4th February 2020

Listed building consent for the erection of 2 No. live-work units; change of use of existing student accommodation including internal alterations to form 2 No. dwellings, 2 No. new windows, new staircase & replacement of roof on outbuilding; reconfiguration of existing dwellings, replace existing timbers & roof joists on first floor; change of use from medical centre/offices to 2 No. flats & workshop. creation of new private gardens, separation of this part of the site from the wider University campus, creation of a shared landscaped courtyard, creation of areas for parking & storage for bins & cycles.

65 Upper Bognor Road (Charlotte House 71 & 71A Upper Bognor Road, 67 & 69 Upper Bognor Road Bognor Regis

Thank you for your internet representation made on 4th February 2020 which has been recorded as '**an objection**' with the comments as follows:

Drawing
New Live Work Units
ElevationsProposed

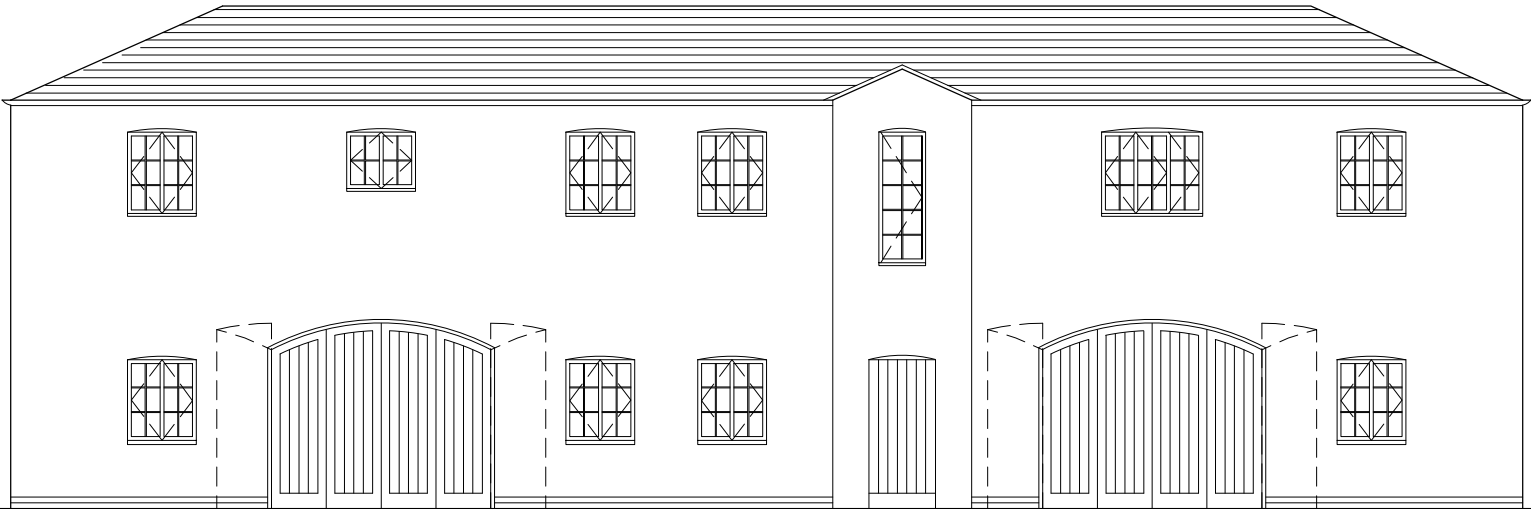
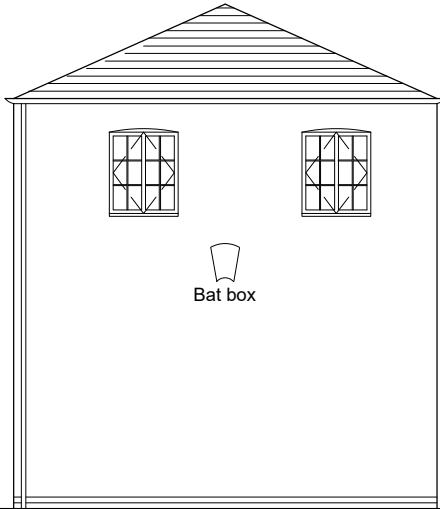
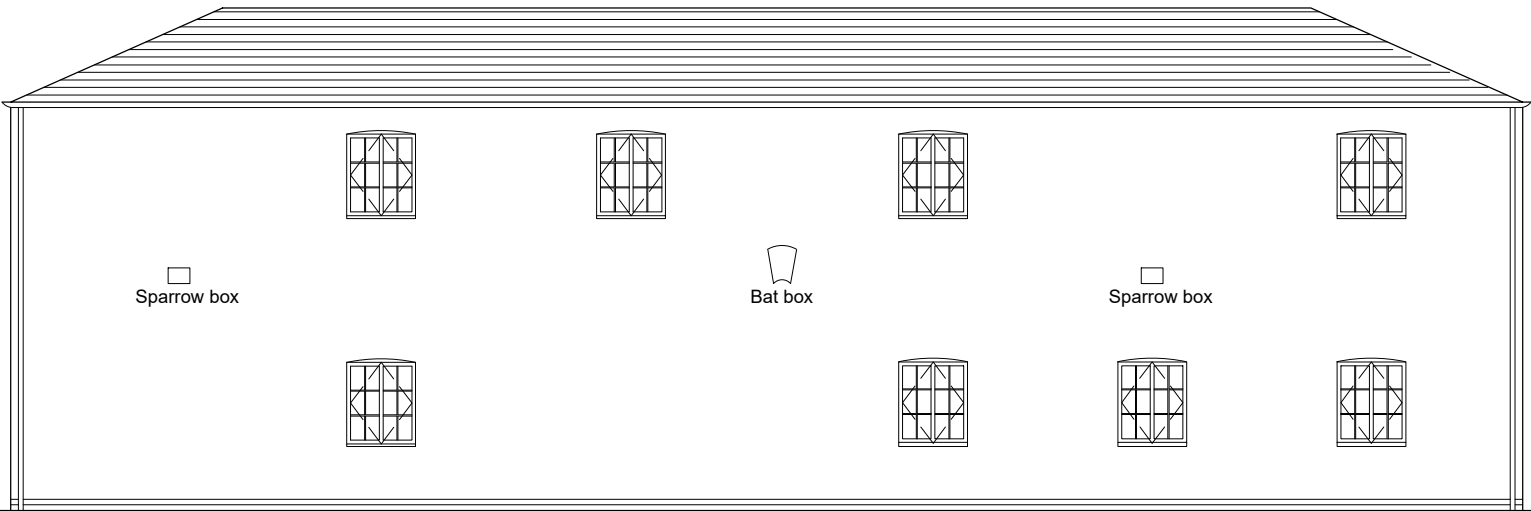
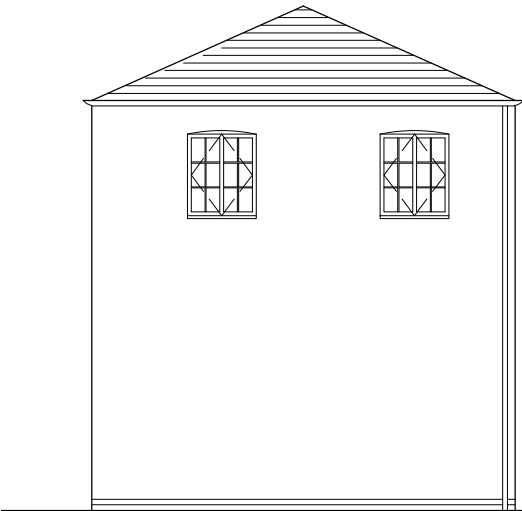
The Panel welcomes the conversion of the existing buildings and the design approach taken. Precise details of materials, finishes and new joinery need to be agreed with the LPA. However, our objection is based on the poor design quality of the new building. There is an odd window to wall ratio and the incongruous appearance of the lobby and staircase area. In addition there needs to be greater over style and depth to the eaves.
